Town and Country Planning Act 1990 (As amended)
Town and Country Planning (General Permitted development) Order 2015 Schedule 2 Part 1
Class A
Application for Prior Notification for a householder extension

Development Notification under extended permitted development rights for new proposed extension extending 5.5m from the original rear wall of the dwelling house. 2.9m high with an eaves height of 2.1m

Location 10 Cohen Close Aldingbourne

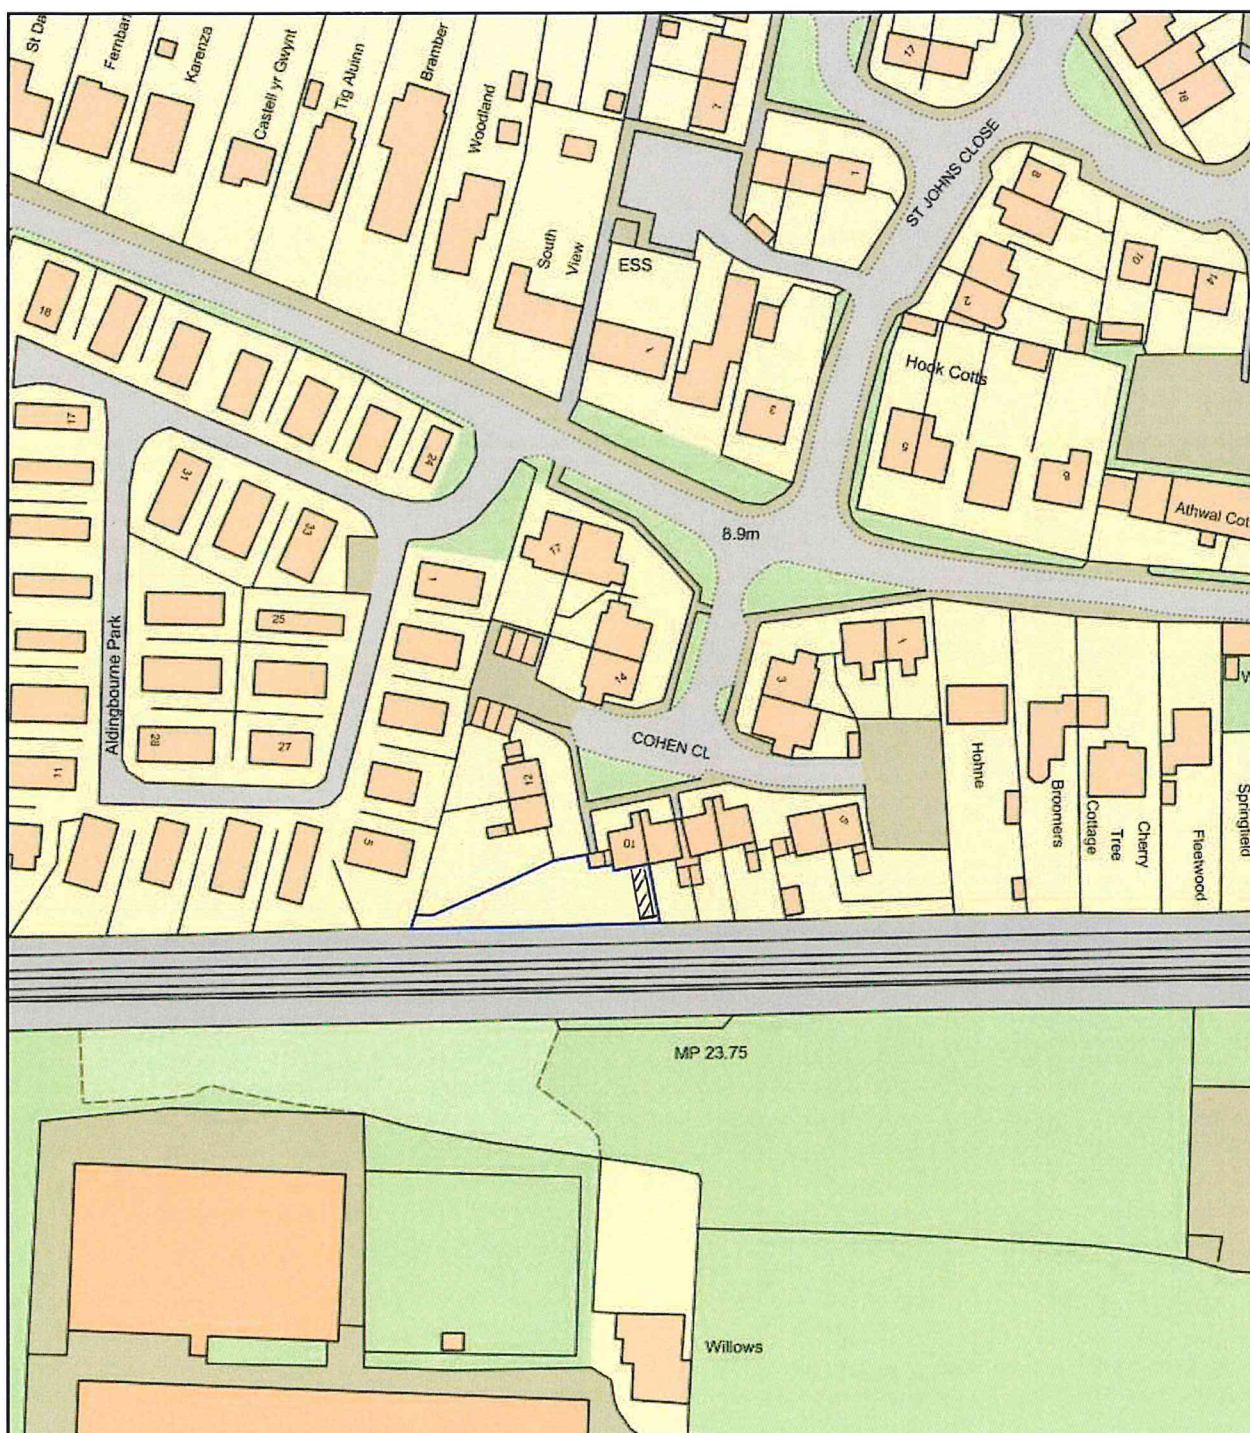
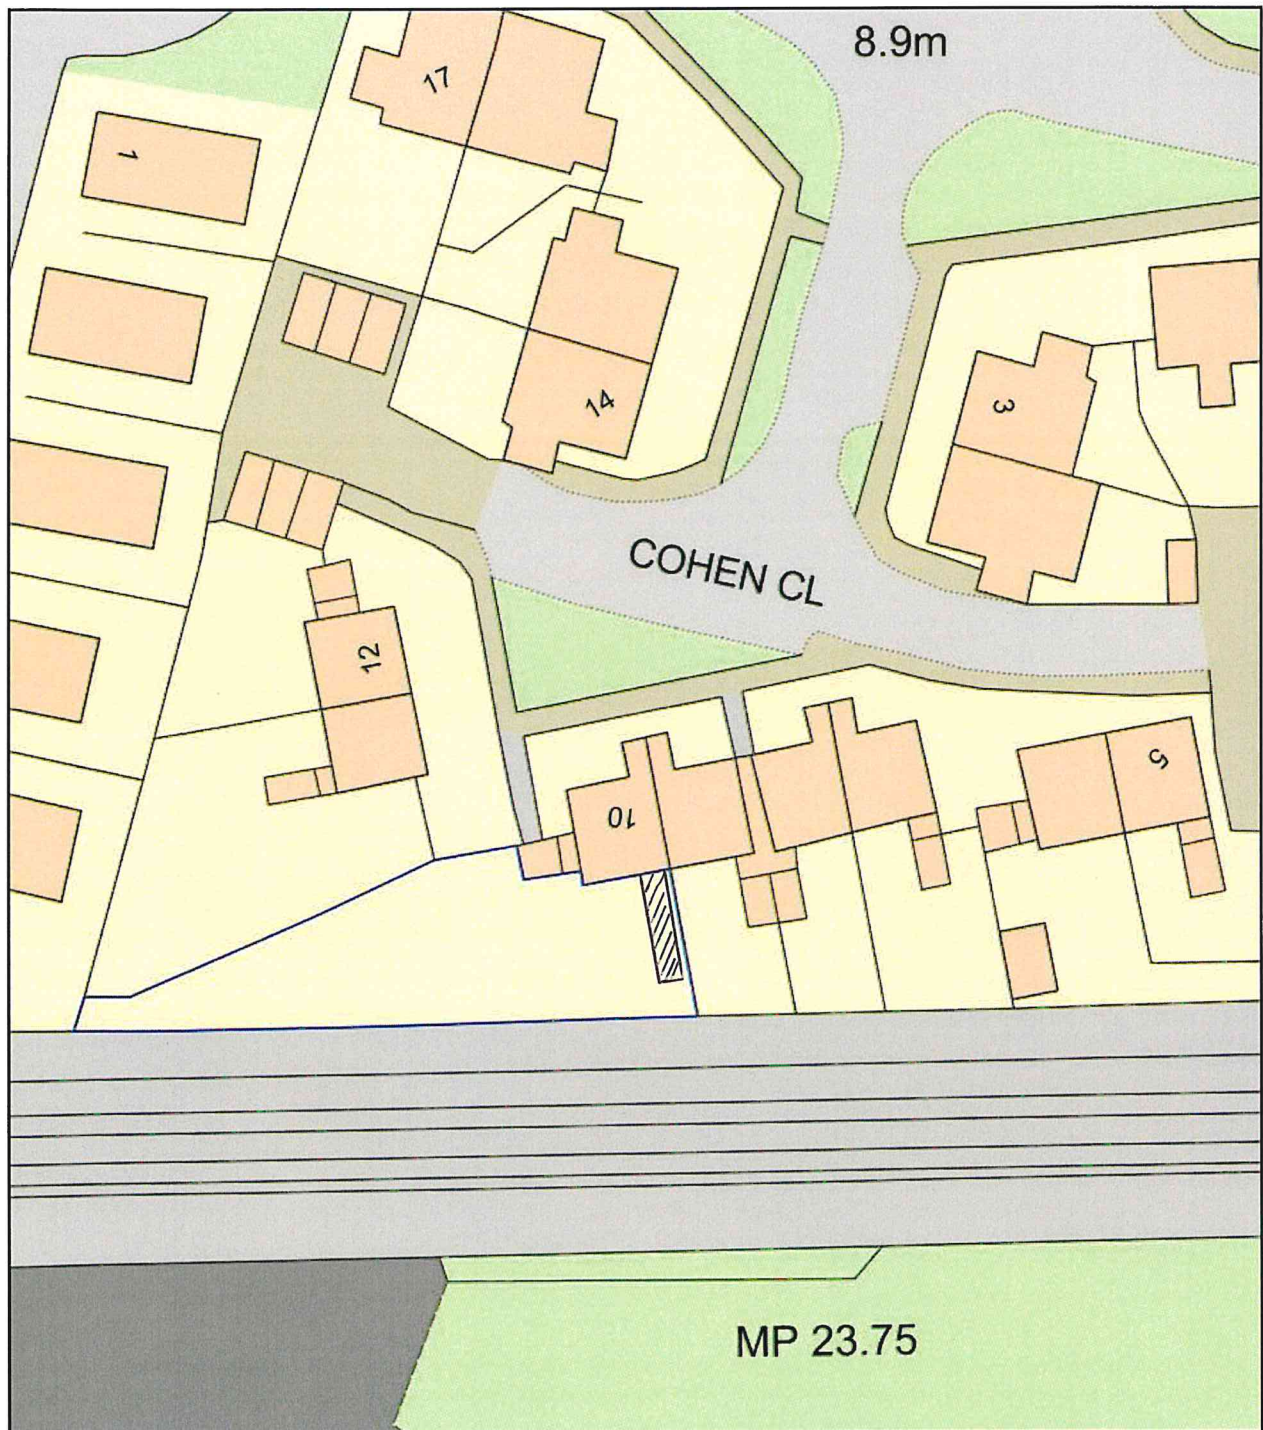
Please amend the submitted location and block plan to show the proposed extension clearly, unfortunately the red edge on the submitted plan seems to be an 'odd' shape.
